Our ref: P01334150
29 March 2021

**T&CP (Development Management Procedure) (England) Order 2015
& Planning (Listed Buildings & Conservation Areas) Regulations 1990**

**LAND AT FORD ROAD, ARUNDEL, WEST SUSSEX
Application No. AB/135/20/OUT**

Illustrative Masterplan

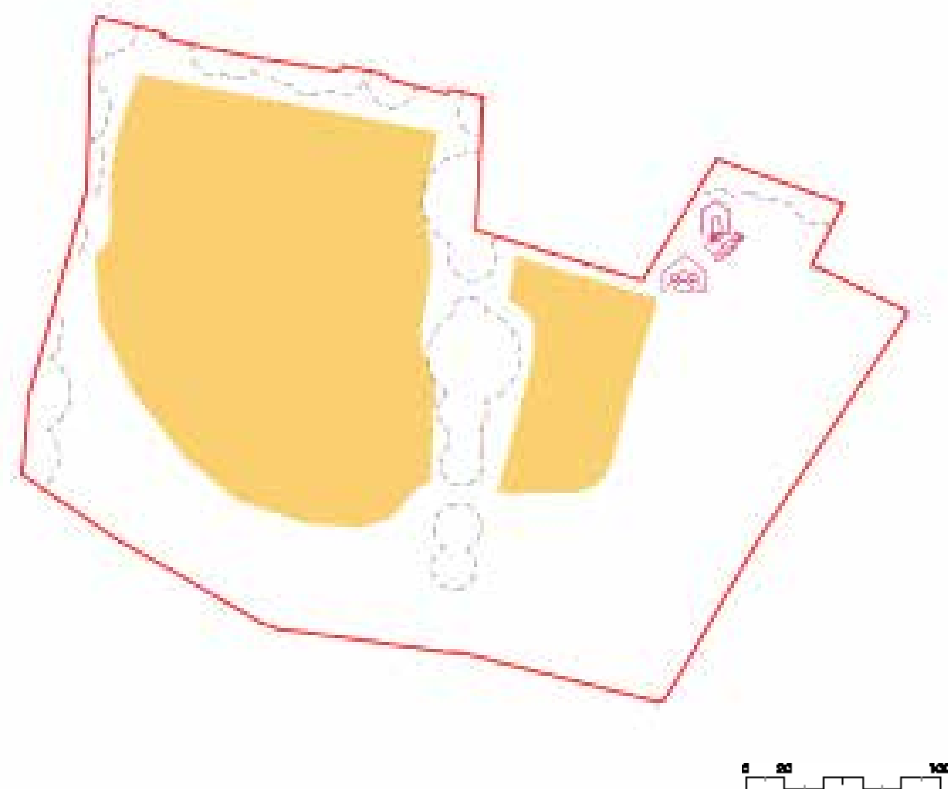
out the Masterplan should be reconsidered to improve the outcome for the historic environment, including the settings of heritage assets. The Heritage Statement indicates that the Illustrative Masterplan has been revised.

We would be happy to comment on this revised Masterplan if you so wish. It would be useful for the applicant to confirm the ways in which the revised heritage assessment has been used to inform the revised Masterplan.
